## City of Albuquerque

RE: 820 First Street NW (Dated September 14, 1983)

CONFERENCE RECAP

SUBJECT: 820 1st St N.W.

SITE PLAN, DRAINAGE PLAN

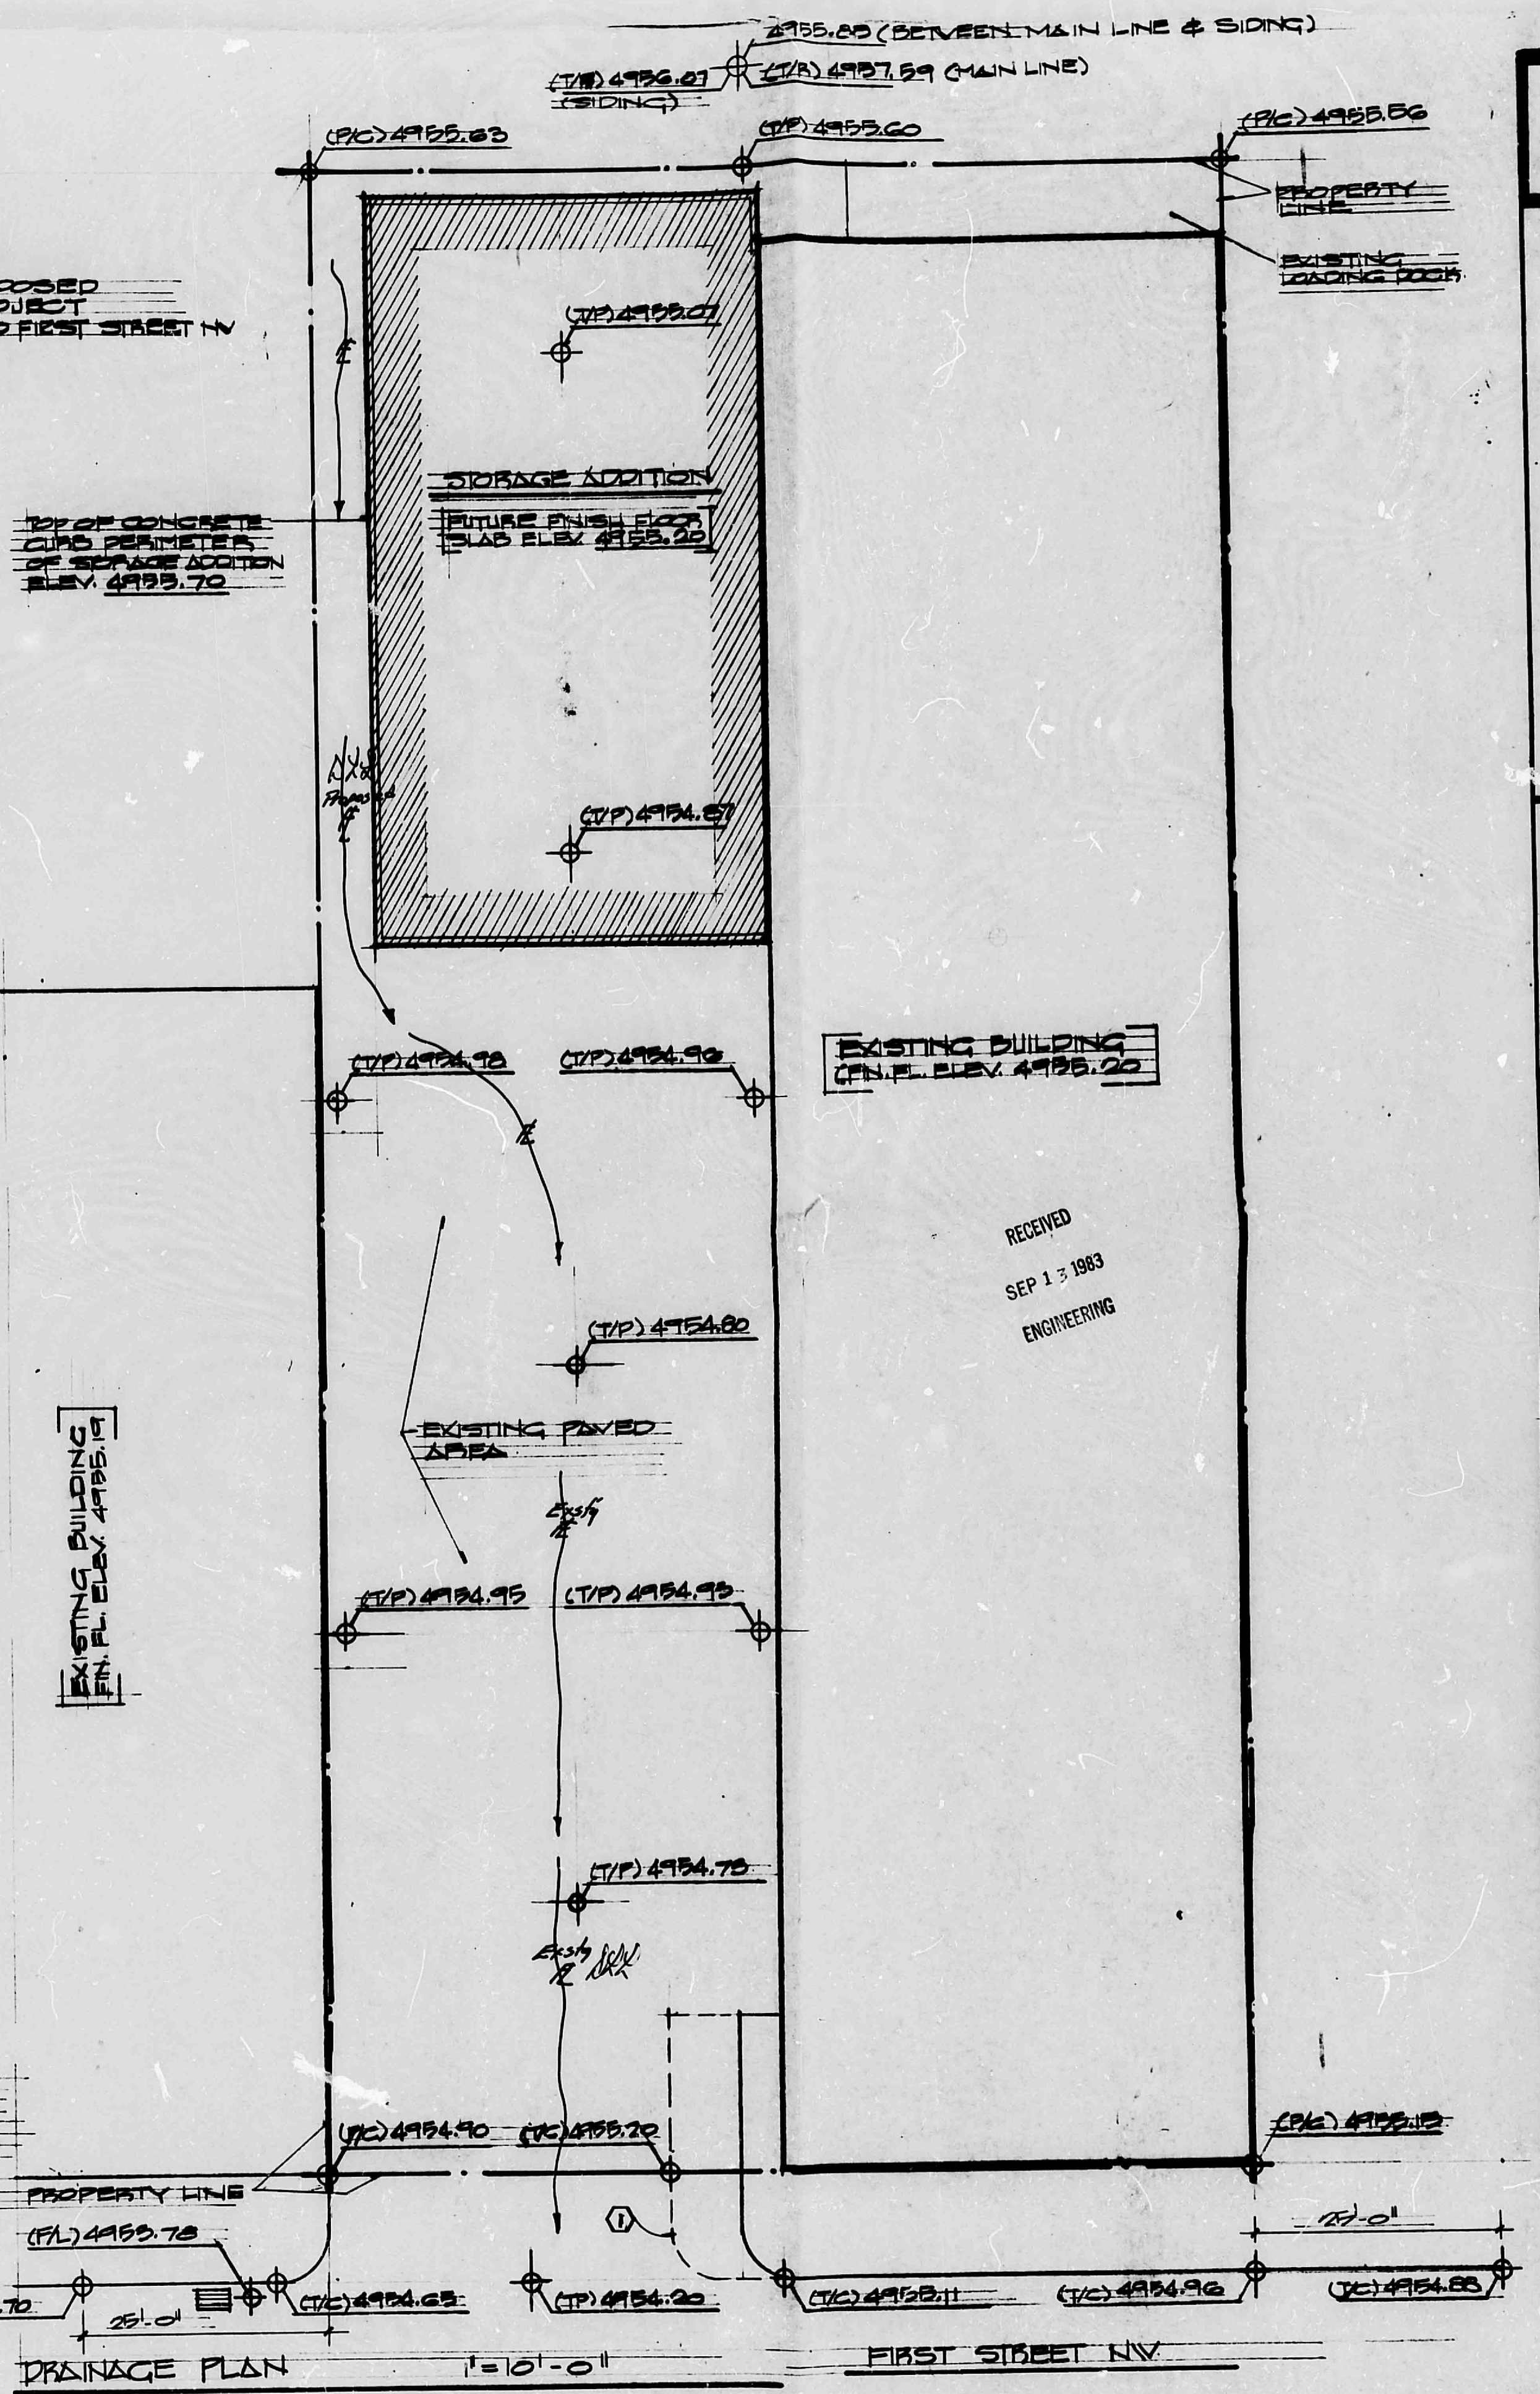
The referenced drainage plan is approved; however, I would recommend that your client raise the finished floor elevation one (1) foot above the top of the curb in view of the "AO" (Depth 1) zone designation for First Street as identified on the Flood Insurance Rate Maps. The building plans will be signed off with the inclusion of the approved plan in the building set.

1. DRAINAGE PLAN REQUIRED, L.L., A SITE PLAN SHOWING  
THE EXISTING STRUCTURES ON SITE WITH THE PROPOSED DEVELOPMENT  
IDENTIFIED ON THE PLAN.
2. SHOW EXISTING ~~DRAINAGE~~ AND PROPOSED DRAINAGE PATTERN
3. IDENTIFY ANY OFF-SITE ~~AND/OR~~ ON-SITE <sup>(CONNECTIONS)</sup> THAT MAY ~~BE~~  
ADVERSELY AFFECT PROPOSED DEVELOPMENT OR EXISTING STRUCTURES.
4. RECOMMEND FINISH FLOOR BE ELEVATED ABOVE TOP OF CURB.  
PROVIDE MSL ELEVATION TO DEMONSTRATE THIS ~~AND~~ CRITERIA
